Subject: RE: BE/109/19/OUT - Land East of Shripney Road

Whilst writing the report, I have noted that the site is Grade 2 Agricultural land as per the Post 1988 Agricultural Land Classification (England) mapping which I believe is based on MAFF surveys between 1989 & 1999. I can proceed with the recommendation but in accordance with policy SO DM1, you will need to provide us with mitigation measures and a soil resources plan for the development site. Our legal advice is that it has to be provided before determination and cannot be a condition. This approach was demonstrated with recent applications Y/103/19/PL & Y/83/19/OUT to name a couple. I believe that I can get this on the agenda on the basis that they will be with us before the Committee Meeting on 8th April. Can you provide this/these by the start of that week (6th April)?

Figure 10 - Agricultural Land Classification

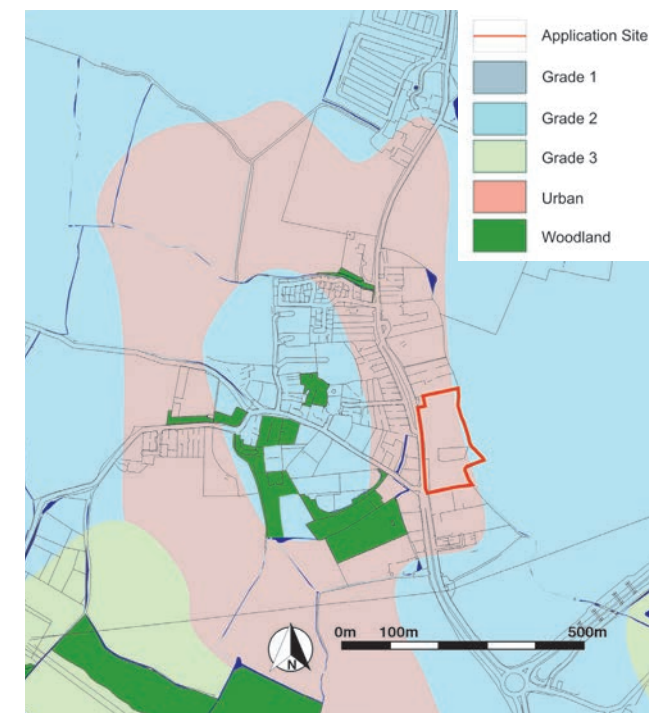
I note your point but also that the plan seems to show a dualled A29 all the way to the north of the village (e.g. up to level with the caravan park!) which is simply wrong. So its just not accurate enough and certainly less useful than the MAFF data. I also note that the page link below sets out the following disclaimer:

My colleague in Policy has confirmed that the map in the ADC 2017 LCA is based on the updated Natural England mapping so therefore this would supersede the Magic mapping. However, it does appear from the online NE maps (<http://publications.naturalengland.org.uk/publication/141047?category=5954148537204736>) on which the map in the LCA and your LVA are based, that the urban area classification does not extend onto or beyond the southbound

carriageway/eastern side of the A29. The NE mapping suggests that the land on the eastern side of the A29 is entirely within Grade 1. See below extract.

We as officers use the Magic mapping to determine agricultural land quality and I was not aware of any other sources. Please can you advise where the extract transposed into DLA's LVA comes from. I have been reviewing our 2017 LCA and also our "Landscape & Visual Amenity Aspects of Development Choices in Arun District 2006" and cannot see where the map was taken from. I will then need to speak to the Group Head of Planning to see whether the mapping that shows it as urban land takes precedence over the ALC.

Anyway, we have taken the decision to proceed with the soil resources plan/report which will be completed by Reading Agricultural Consultants this week. They have been asked to examine the categorisation of the land as part of their assessment.

I have reviewed the MAFF data on Magic and so understand your conclusion that the land is Grade 2. This is based on the closer detailed 1994 survey (see attached) and not the regional mapping update in 2010 by Natural England (which I assume informs ADC's 2017 LCA) which is at a broader scale. I would note however that the Council's 2017 Landscape Character Assessment which Davies Landscape Architects transposed into the submitted LVA as shown on pp17 Figure 10 highlights the site is within an urban area classification instead, see below. Any information / clarification you can provide on this might be helpful ahead of the report being produced as based on the LCA we need not undertake this work.

I don't know the precise reasons why the classification might have changed (assuming it has) but I have considered that this might logically be because (as detailed in the submitted Utility Assessment) the land as it hosts an 18-inch water main laid which runs diagonally through the centre of the site (with easement restrictions), and a sewer main running north/south through the western part of the site (again with applicable easement restrictions). It strikes me that these features may well undermine the land classification as in combination with the small parcel size, it further

Therefore we will ask the consultant to also attempt to accurately conclude on the land classification as this is also important for your determination.
